From: Simon Davis
Sent: 26 November 2020 12:25
To: Planning Scanning
Subject: FW: Open Space to south of Summer Lane

P/70/19/RES - Application Correspondence, label as "Information on land raising within POS Area"

From: Simon Davis <Simon.Davis@arun.gov.uk>
Sent: 23 November 2020 16:56
To: Daniel O'Shea <[REDACTED]>
Subject: Open Space to south of Summer Lane

Figure 3b – Public Open Space Landscape Strategy (from IJLA, 2019)

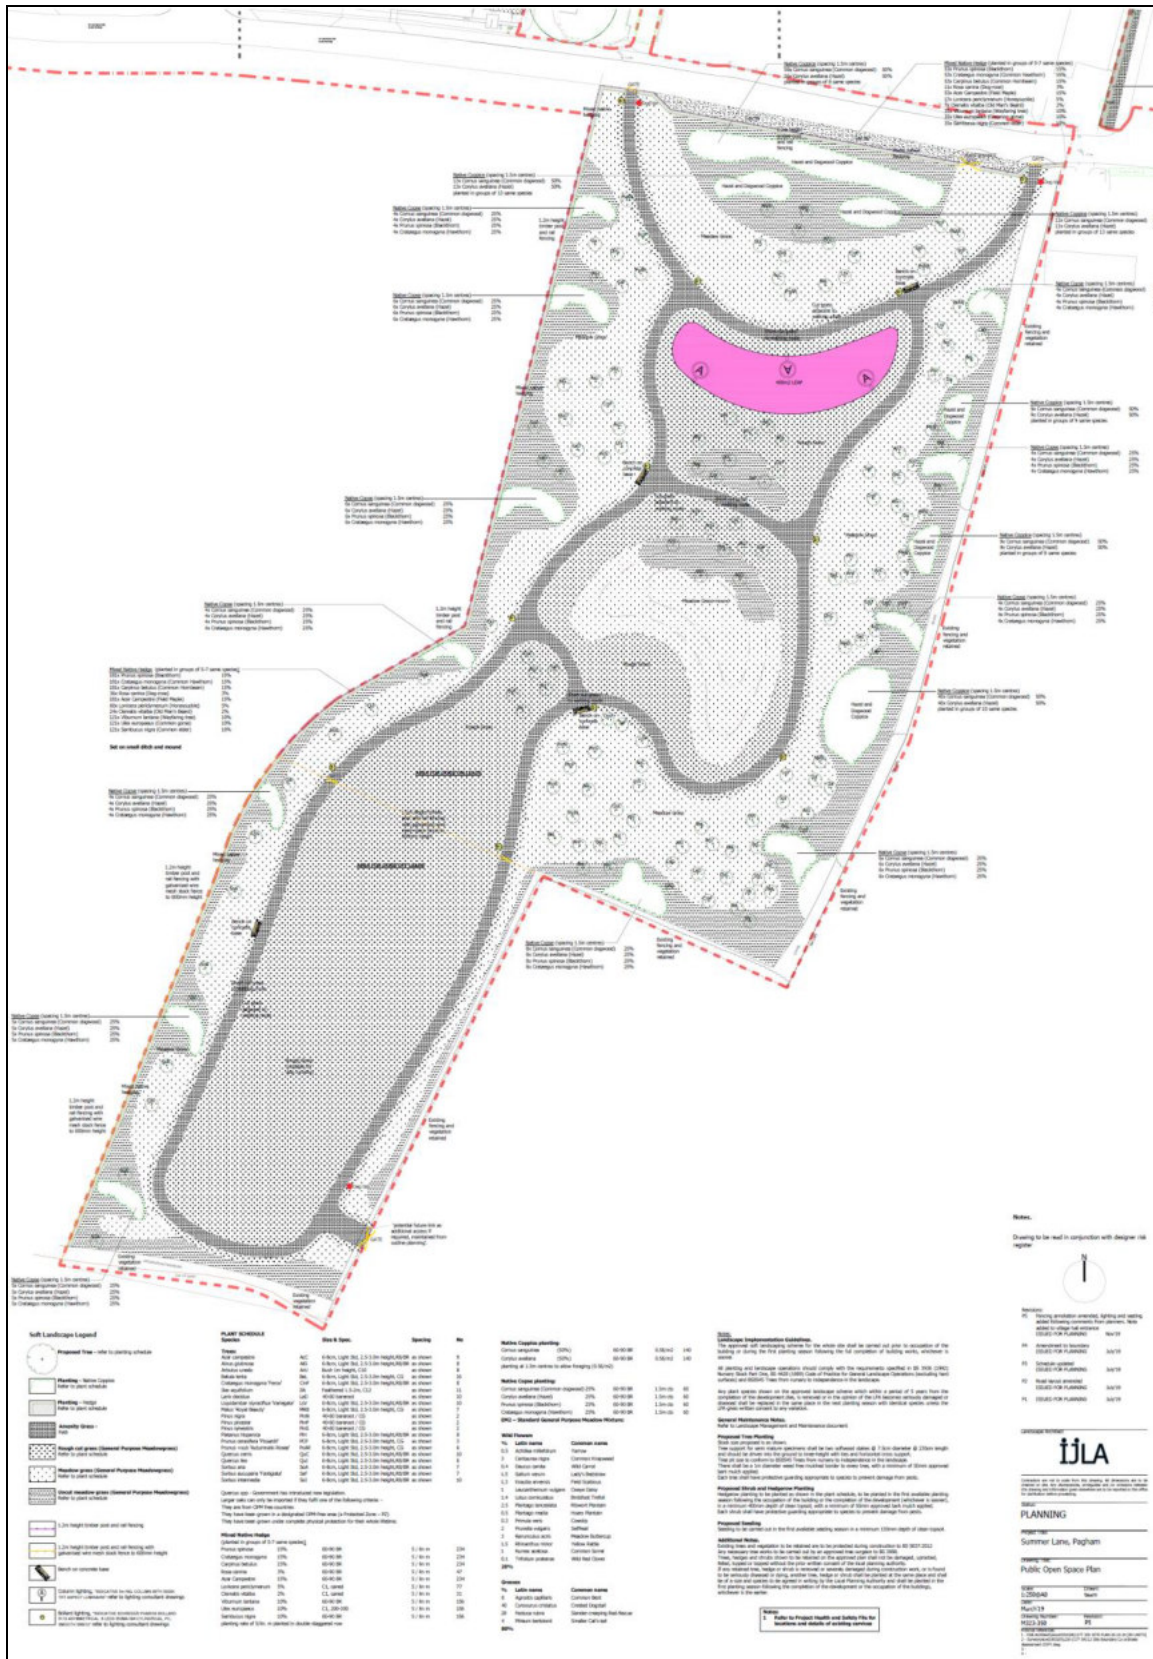
I'm sorry, I couldn't see the mound when I first looked at the plan but I can now see it. However, can you advise how high this will be as there is no detail on that aspect.

I have a resident asking me why you are moving earth from the north side of Summer Lane onto the open space area to the south. The resident alleges that a bank is being created near the boundary with existing houses (I believe this to be on the eastern side of the open space). Can you advise what is going on please?

No problem, it's not exactly obvious amongst the other hatching, but the proposal is that the contours would be approx. 1m intervals and they are drawn at 3m offsets so that it would be a comfortable 1:3 slope. Therefore with the bottom contour being at the ground level the 3rd contour could be at circa 2m height and then crowned.

Around the edges, the hedges are raised on small engineered banks/shallow ditches, to provide microhabitats in accordance with the Ecological Mitigation Strategy.

Within the approved POS plan there is a grass mound to be formed in the middle of the site, along with bunding around the edges. The earth has therefore been removed from the north to level the site and enable the excess to be utilised in forming the raised elements to the south.
